Rezoning Transportation Analysis

Petition Number: #2022-090

General Location Identifier: 02529122

Date	Description
11-28-22	First Review (TM)
01-25-23	Second Review (TM)
03-23-23	Third Review (TM)
04-27-23	Fourth Review (TM)

RZ1.00

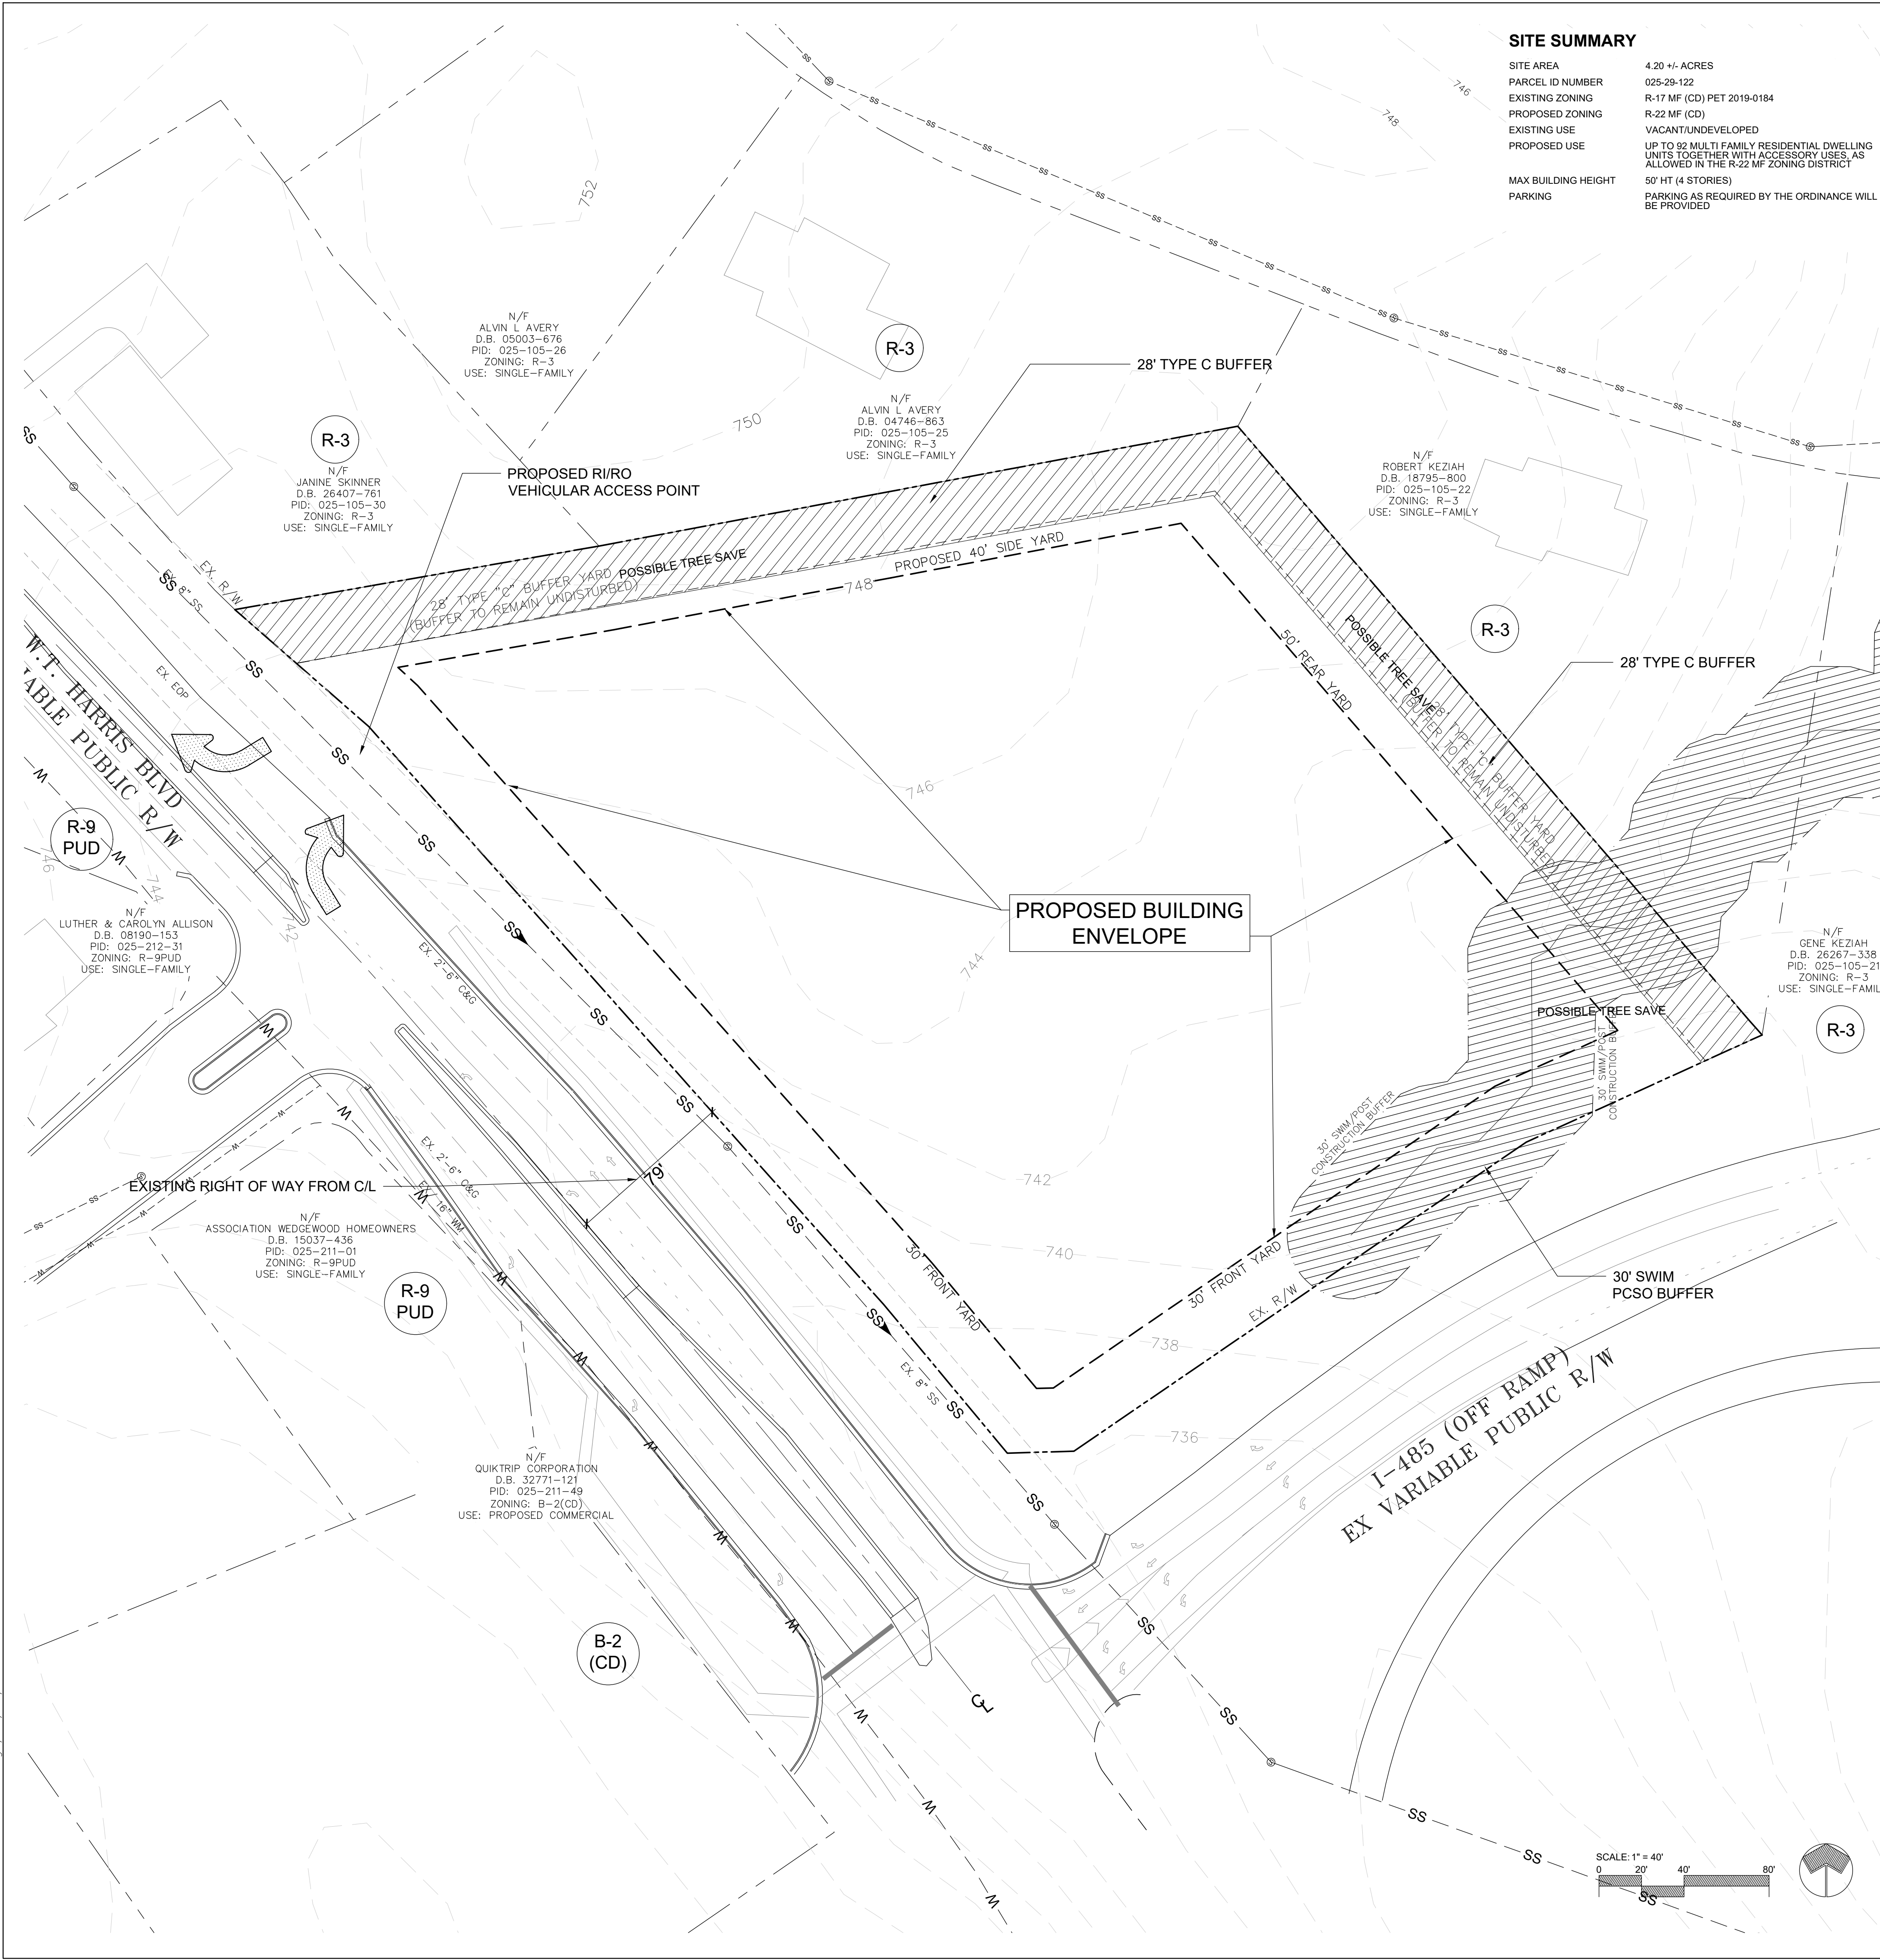
1. ~~**Curbline:** The proposed zoning district has a setback measured from back of the existing or proposed future curbline.~~

a. ~~**WT Harris Boulevard:** The future location of curb and gutter is in its current location. Proposed curb and gutter along site frontage must match existing back of curb.~~

~~Label and dimension the curb and gutter from the centerline for each road on the site plan.~~

3. ~~Revise site plan by labeling and dimension the right of way from the road centerline.~~

4. ~~Site plan and conditional note(s) revisions are needed to commit to construct curb and gutter from existing curb and gutter to the Northern property line of the site. Curb and gutter shall be labeled and dimensioned from the centerline of WT Harris Boulevard on the site plan.~~

Outstanding Comment from 01-25-23: label and dimension curb and gutter on the site plan.

5. ~~Revise site plan by showing proposed 8 foot planting strip, and 12 foot sidewalk on WT Harris Boulevard as committed to in conditional notes. This meets chapter 19 requirements. The site plan shall label and dimension both items from the back of curb and gutter and road centerline.~~

6. ~~Revise site plan and conditional note(s) to provide a right turn lane at the site entrance with 100 feet of storage. Site plan shall dimension the storage length and the length of the taper. Add a conditional note noting the right turn lane improving.~~

7. ~~**Outstanding Comment from 11-28-22:** Revise site plan and conditional note(s) to provide a 100 foot driveway stem measured from the proposed right of way. Site plan shall dimension this from the proposed right of way.~~

Clarifying Comment (01-25-23): Driveway stem is measured from proposed right of way. Site plan revisions are needed to show a internal driveway stem from the right of way line

Remove existing conditional note 3D.
